**From:** [REDACTED]  
**Sent:** [REDACTED]  
**To:** Sian Eggington  
**Subject:** RE: Request for further information R/84/20/HH  
**Attachments:** We sent you safe versions of your files; Proposed.pdf; Proposed 2.pdf  
**Categories:** Green Category

**From:** Sian Eggington  
**Sent:** 22 May 2020 11:05  
**To:** Dominique & Gabriel  
**Subject:** RE: Request for further information R/84/20/HH

PART GROUND FLOOR PLAN

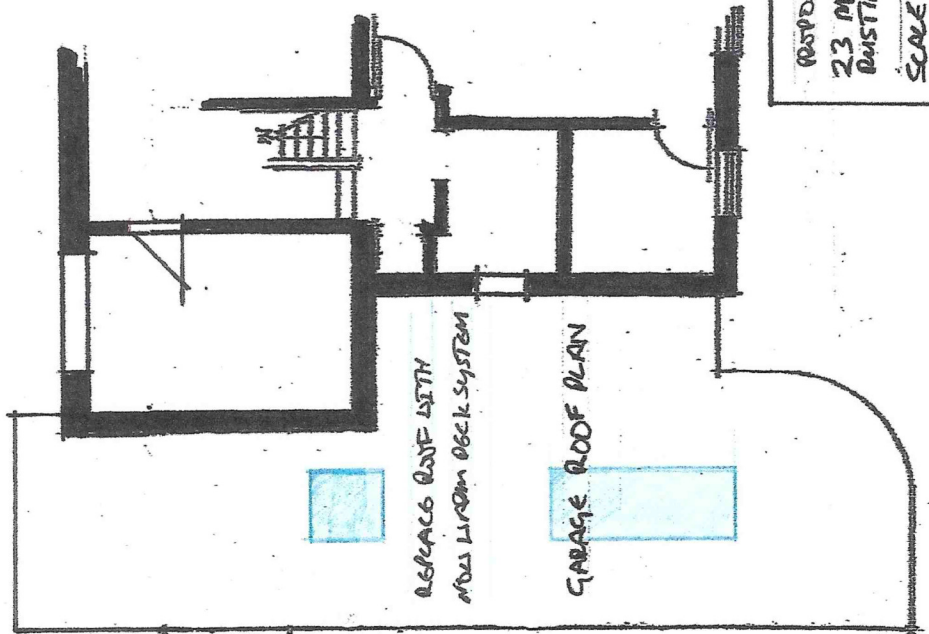
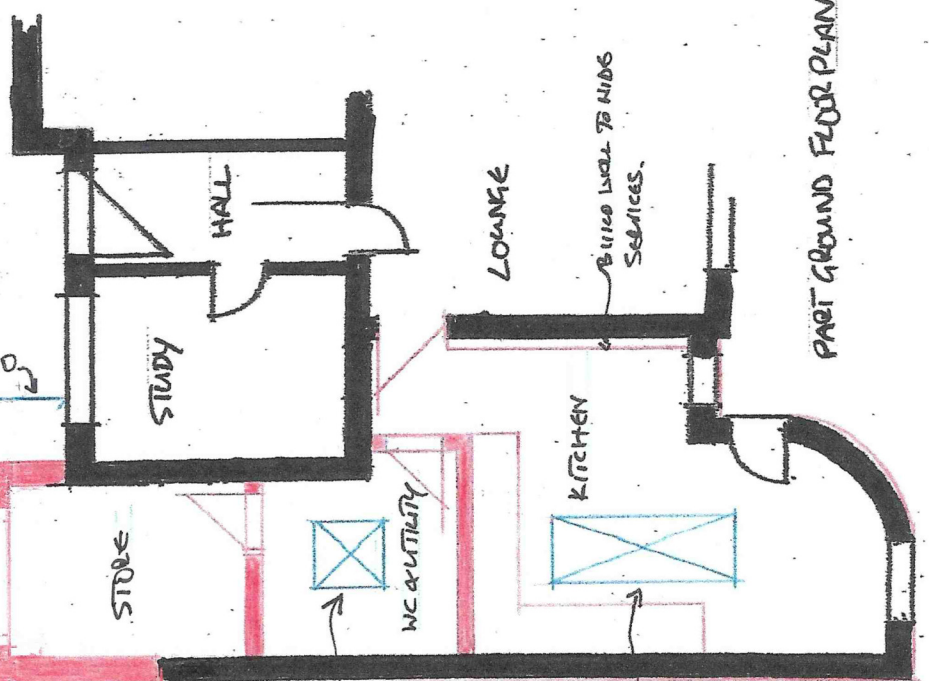
Apologies that it has taken a few days to reply we have had a few issues with the software. I have managed to convert your plans to A4 and all are fine now apart from the attached plan. If you could show the extension up to the red line that I have marked on the proposed floor plan plan (just extend your red line further and show the window on it) then everything will measure to scale then and I will be able to make the application valid. If you have to leave the original extension line in place on the plan in place do not worry I can block over that.

First of all thank you for your support and patience. I hope you are having a nice and bank holiday break. I have revised the drawing to show the extension up to the red line as requested. Please see 'Proposed' attachment.

I was slightly concerned the extension could be misconstrued to project beyond the existing building line (which it will not) and therefore have also provided an additional drawing 'Proposed 2' which keeps the layout 'as is' but shows the extension absorbed into the existing garage. I will leave it to your discretion to use the best solution to validate the application.
